MEMORANDUM

FROM: C.H. Moss, P.E.

DATE: November 21, 2024

RE: Foundation Plan Drawing No. 3843 S-1
Baucom Business Plaza
Fuquay Varina, NC

DRAWING NUMBER
3843

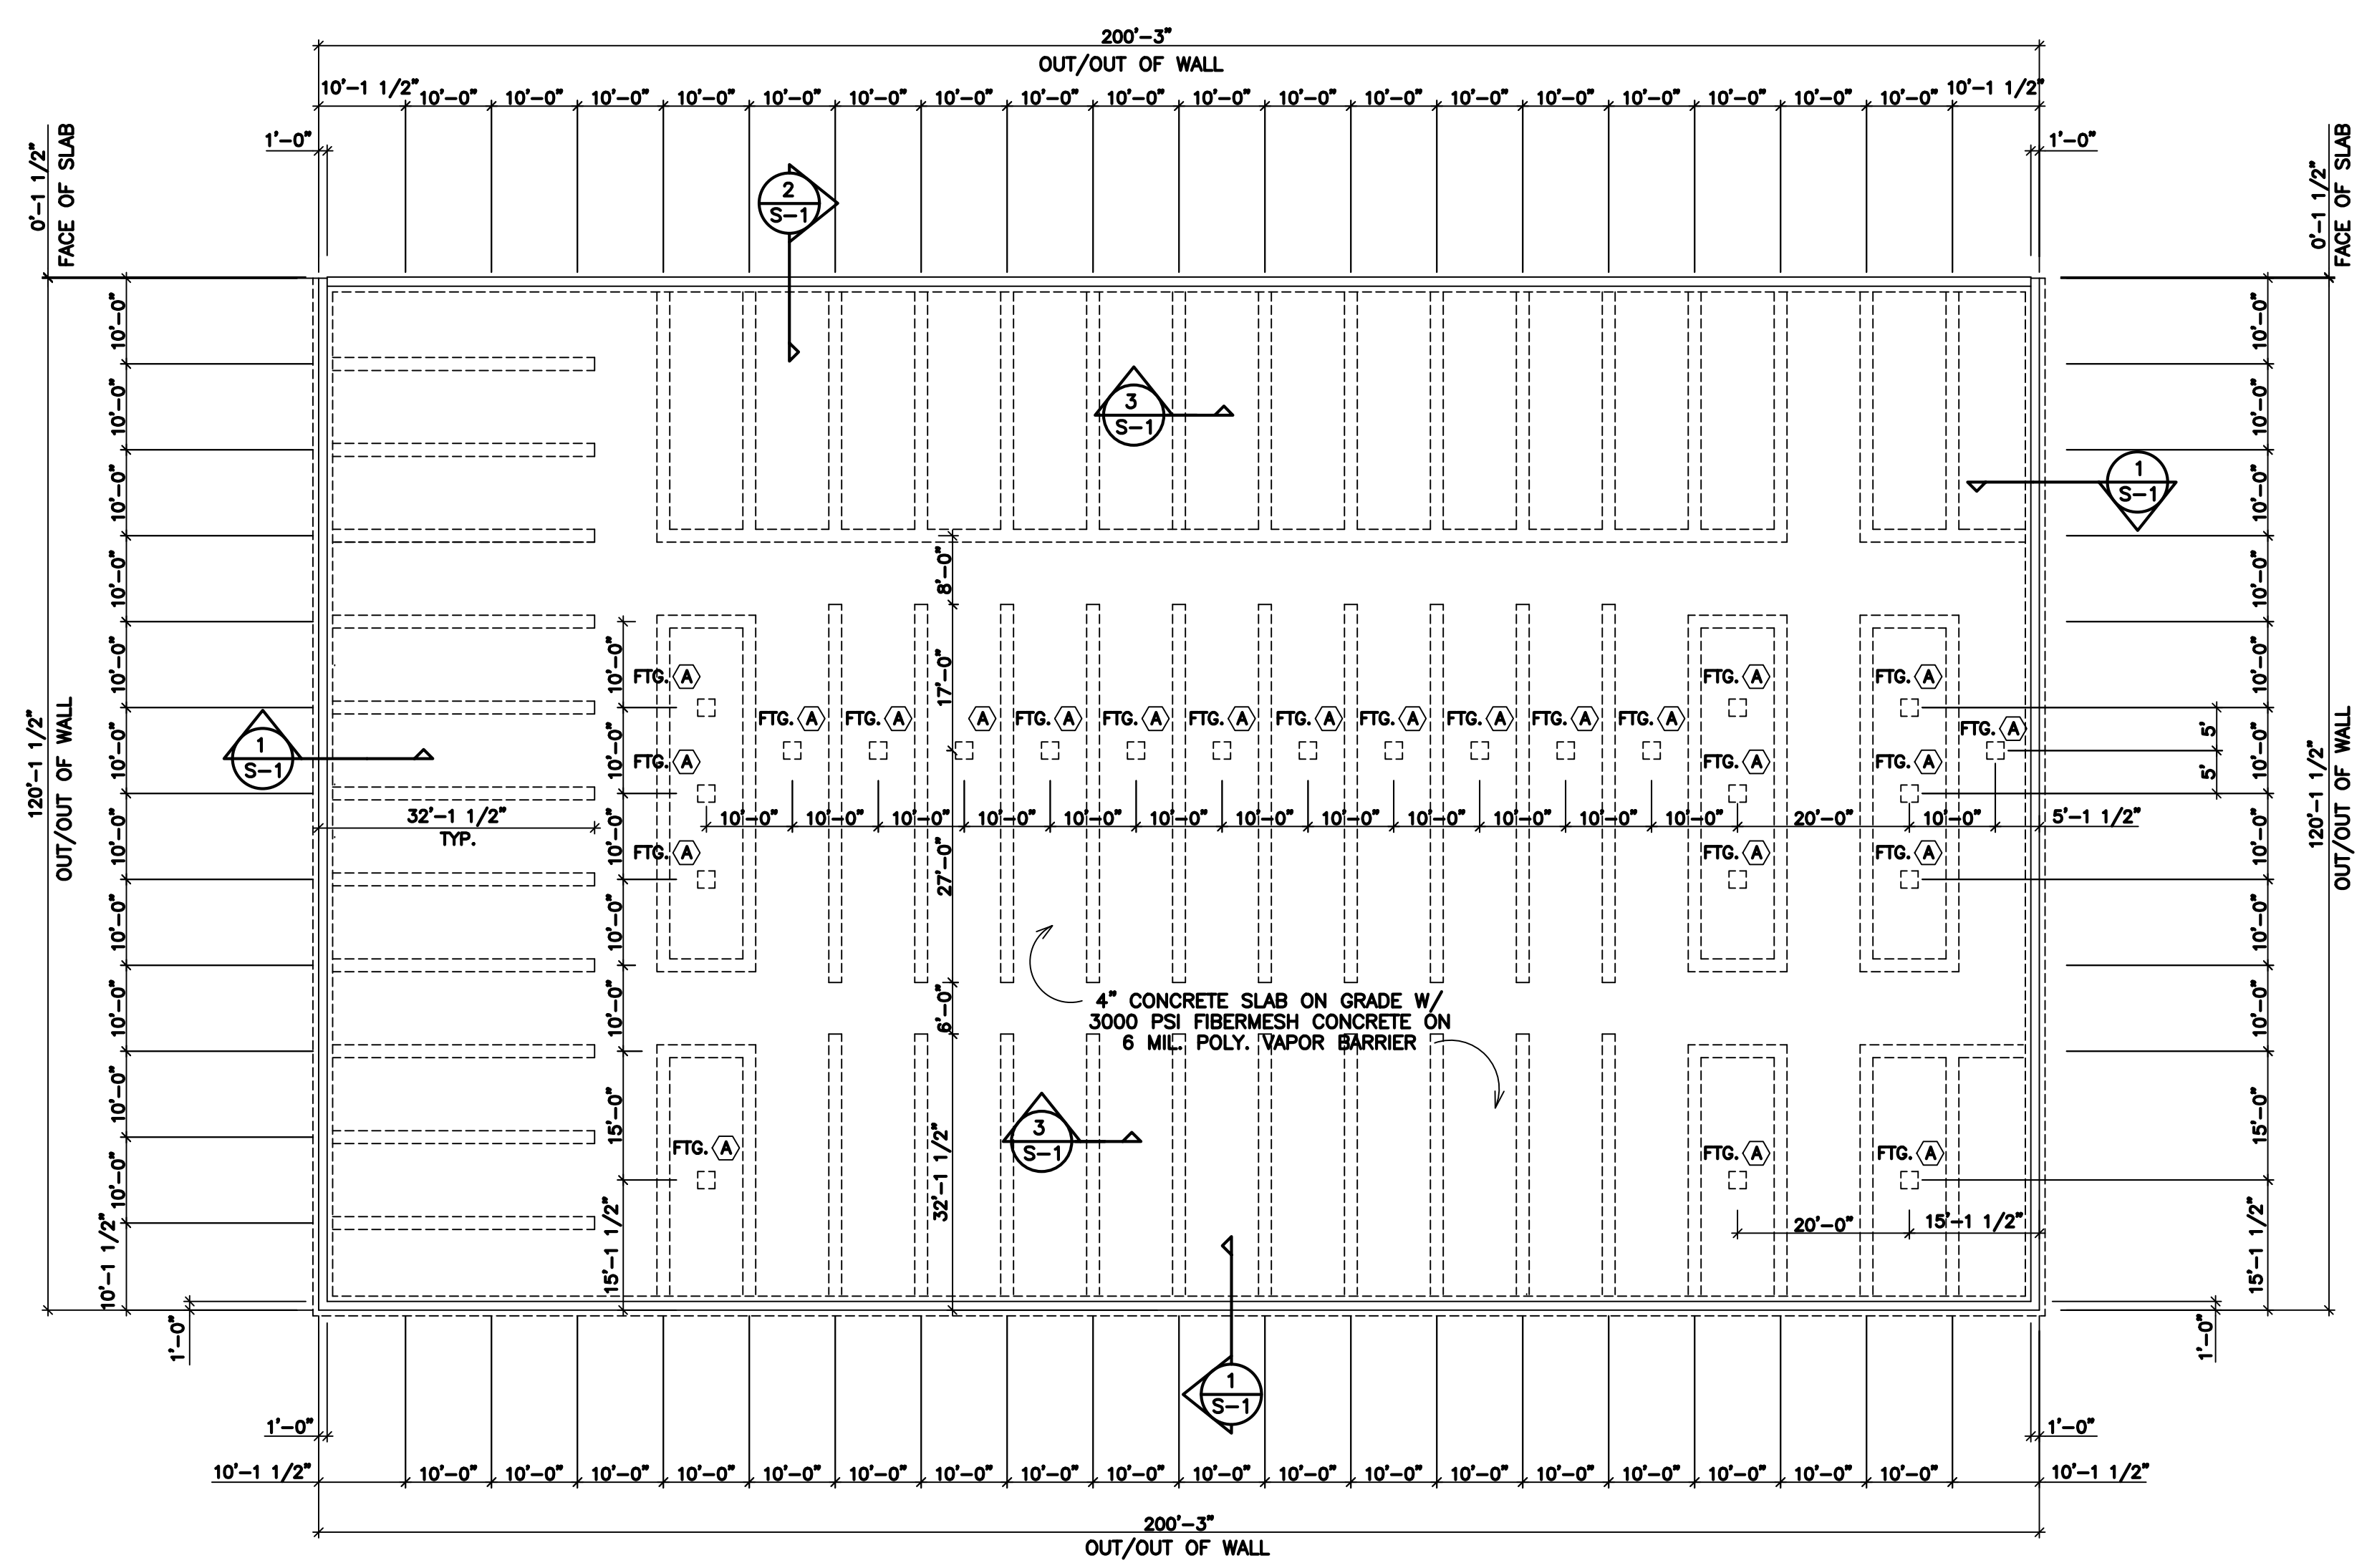
A vertical control joint in the basement wall of the referenced project is acceptable. The wall's structural integrity is not affected by the construction joint. A key way and dowels are placed in the joint to prevent any uneven movements in the two concrete pours.
